KITTTITAS COUNTY COMMUNITY DEVELOPMENT SERVICES

December 28, 2007

RE: Olson Short Plat (SP-07-155)

The Kittitas County Community Development Services Department has determined that the Olson Short Plat is a complete application and hereby grants **conditional preliminary approval** subject to the following conditions:

OLSON SHORT PLAT  
PART OF SECTION 32, T. 20 N., R. 16 E., W.M.  
KITTITAS COUNTY, WASHINGTON

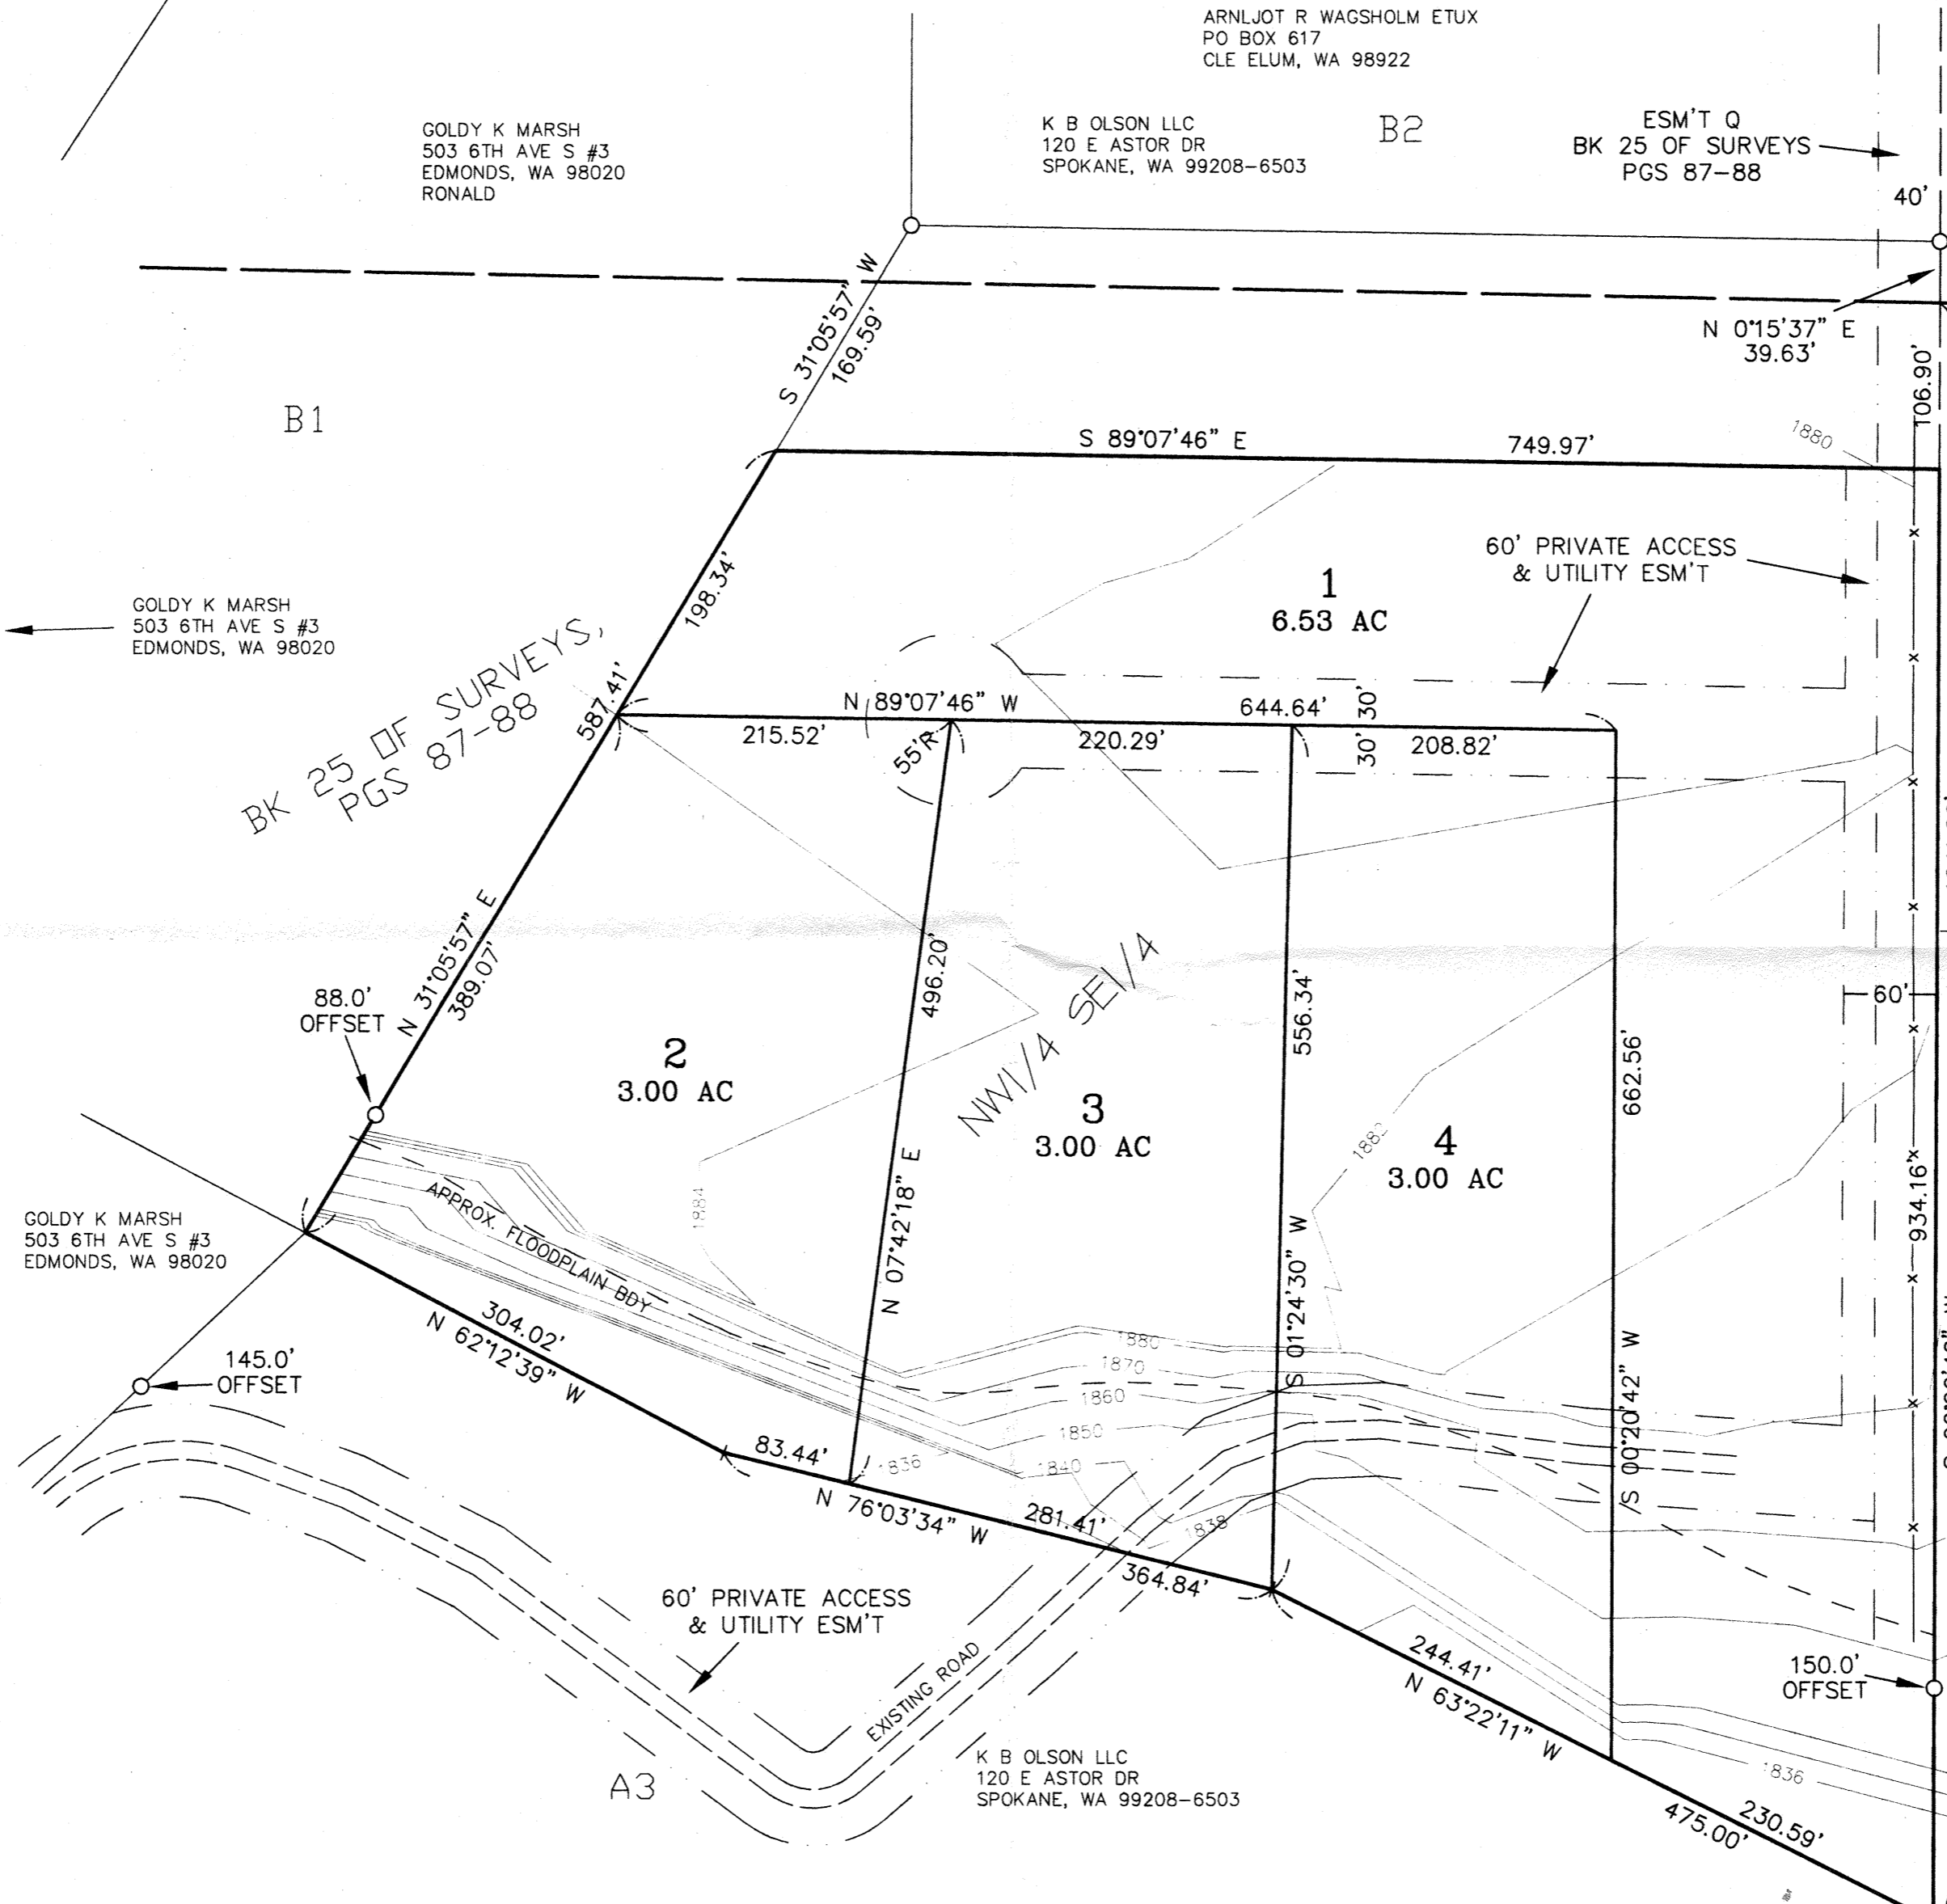
1. Both sheets of the final mylars shall reflect the short plat number SP-07-155 and an accurate legal description shall be shown on the face of the final plat.

4. The boundary of the 100-year Floodplain shall be accurately depicted on the face of the final plat. The applicant shall be aware that future development of the newly created parcels may require a flood development permit and the owner may need to carry flood insurance.
